Application: SSI 7485

I write regarding the proposed modification to M4-M5 Link, Mod 2 The Crescent overpass and changes to pedestrian infrastructure in North Annandale, Rozelle and Rozelle Bay Foreshore area. *I object to the overpass as put forward in the modification and to the relocation of the Green Link*
I request RMS work with the community to explore alternate design options to the proposed new car overpass design and the changed pedestrian and cyclist links. I am seeking the reinstatement of the safe, direct access from the approved EIS GreenLink to create a continuous green open space connection from the Rozelle Rail yards and Annandale to the foreshore. The GreenLink was more than just a walk way - it put people central to the design, maximising safety, and providing much needed accessible open space for the community now and into the future Bays Precinct design.

**Figure 4 | Proposed modification** (Source: Design Amendment Report)

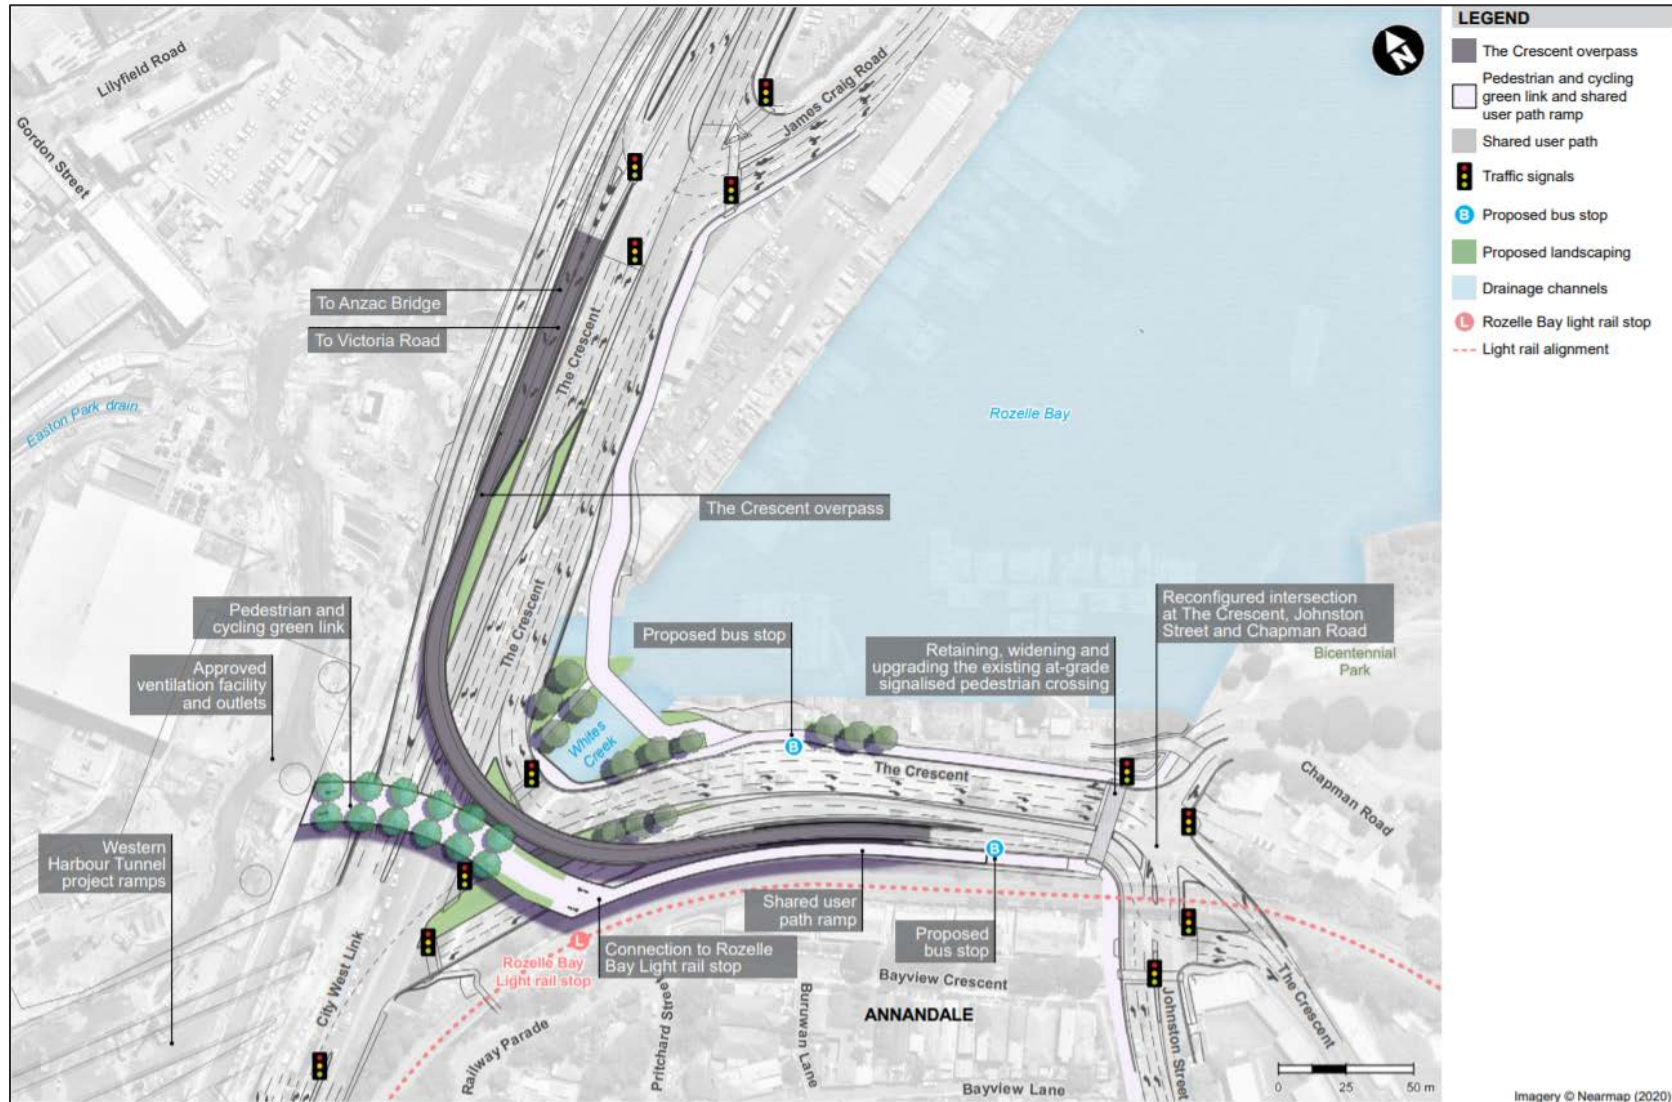
1. The significantly reduced safety and increased risk for pedestrians and cyclists with removed access over The Crescent to Bicentennial Park and the increased traffic along Johnson Street. *Especially with my young kids!*

2. Being required to cross five sets of pedestrian lights at The Crescent as my option to reach the foreshore from Annandale or from Rozelle Bay light rail stop. *Toddlers are terrible waiters, and 5 is way too many to put them*

If there has to be a long, awful concrete bridge, can we at least have some benches to stop to tie shoes, sun cover and garden beds along the way? That way even if my 2 year old gets too tired to make it the full way to the park, it will feel like we've seen a bit of green and had some explore time? Also, PLEASE keep cyclists separate by physical barrier to where we'd be walking with prams and little kids on scooters. There's so many commuters that it would feel like a stressful stampede of wheels vs families if it wasn't safely separated. Which would honestly be scarier than trying to contain an excited, energetic toddler with a bike or scooter at 5 road crossings!

- ✓ • Reinststate the GreenLink connecting communities and green open space from Rozelle to Bicentennial Park
- Relocate and design pedestrian and cyclist connections that are continuous, safe and direct.
- ✓ • Design the modification infrastructure and active links in response to the character of the suburbs, the location of the foreshore and it's potential future development. *All the homes do this! So should the roads.*
- ✓ • Provide pedestrian and cyclist paths that maximise people safety and do not force them onto busier streets, unsafe concrete plazas and caged walkways. *Especially the HUGE population of little people that arent great at crossing roads on their own!*
- Integrate active and direct connections to all active transport - including the future Metro West and Foreshore Ferry Wharf
